The Town and Country Planning Act 1990 (as amended)

Single storey extension between house and garage, partial conversion of garage to form kitchen.

22 Oakwood Drive Angmering

PROPOSED FRONT ELEVATION

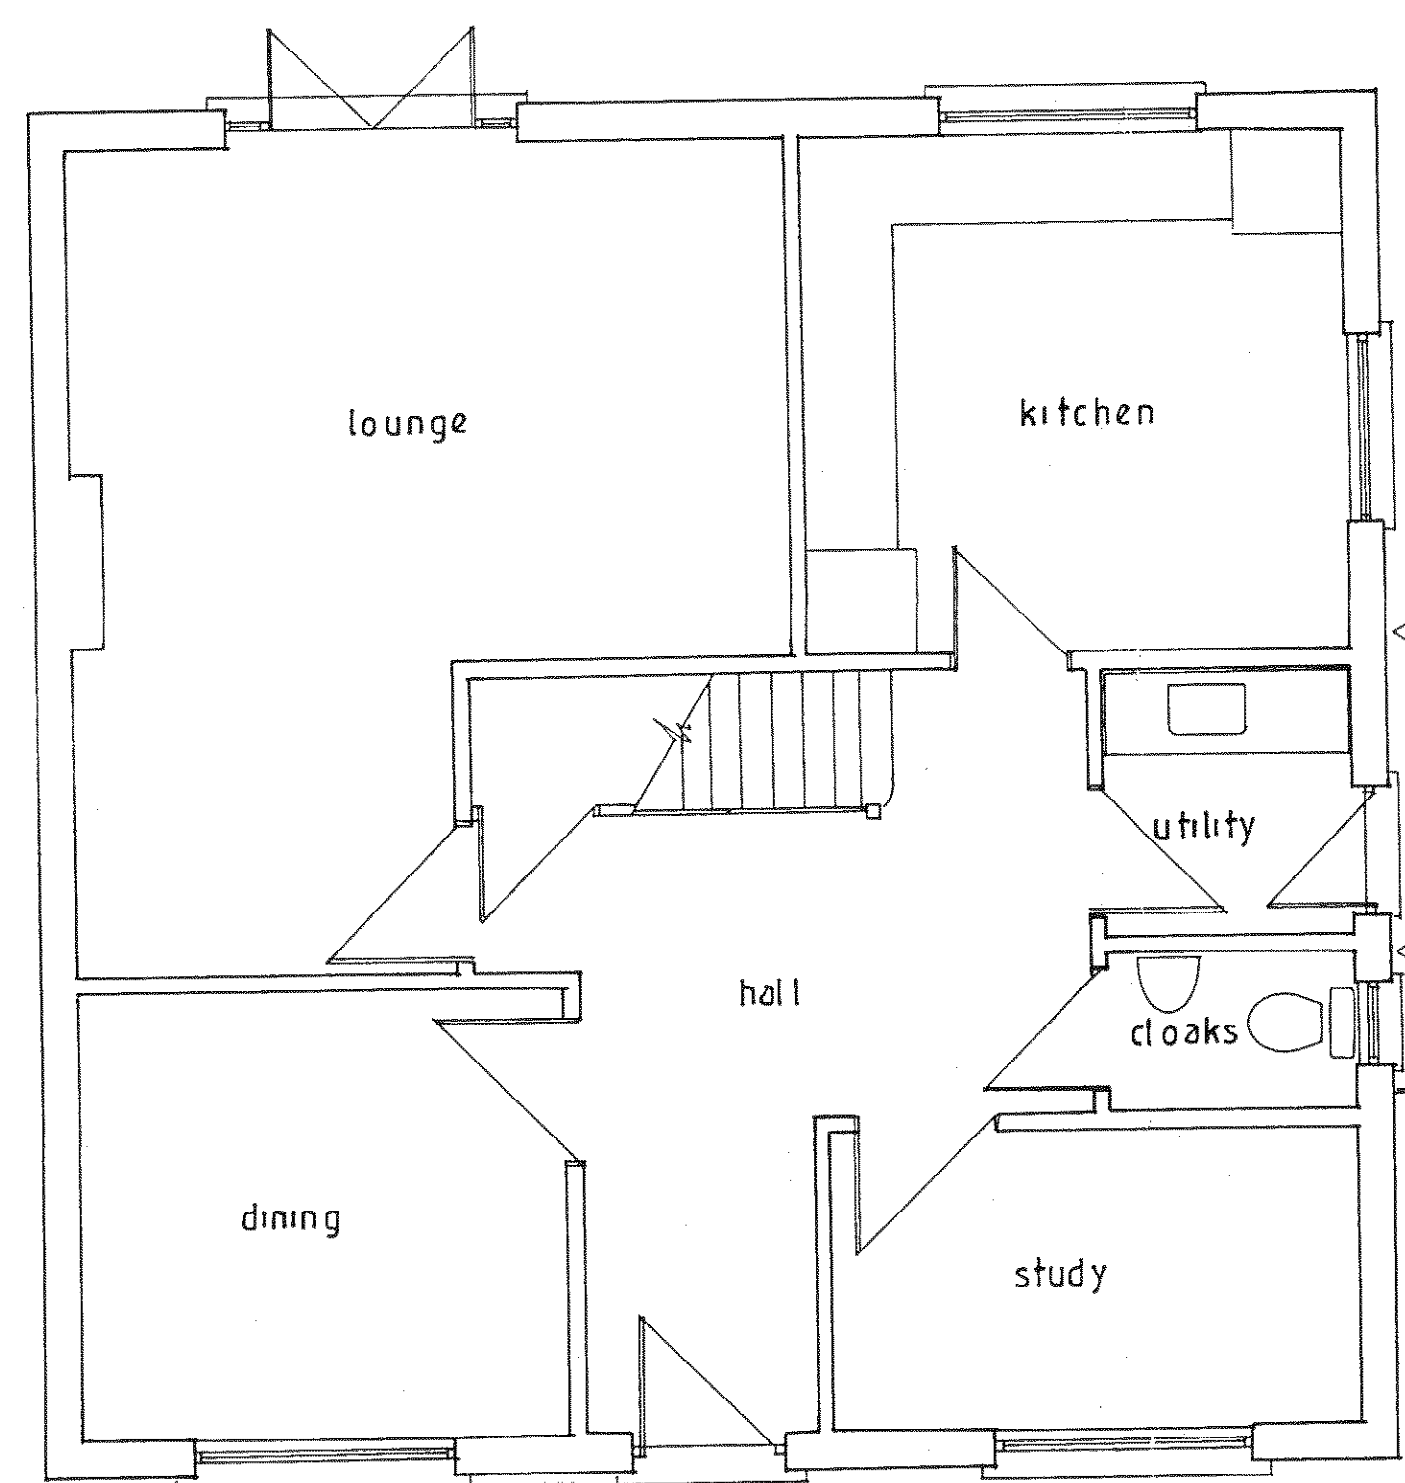
We object to the design and appearance of the building because of the number of conflicting roof lines and lack of light and ventilation in the kitchen and utility room
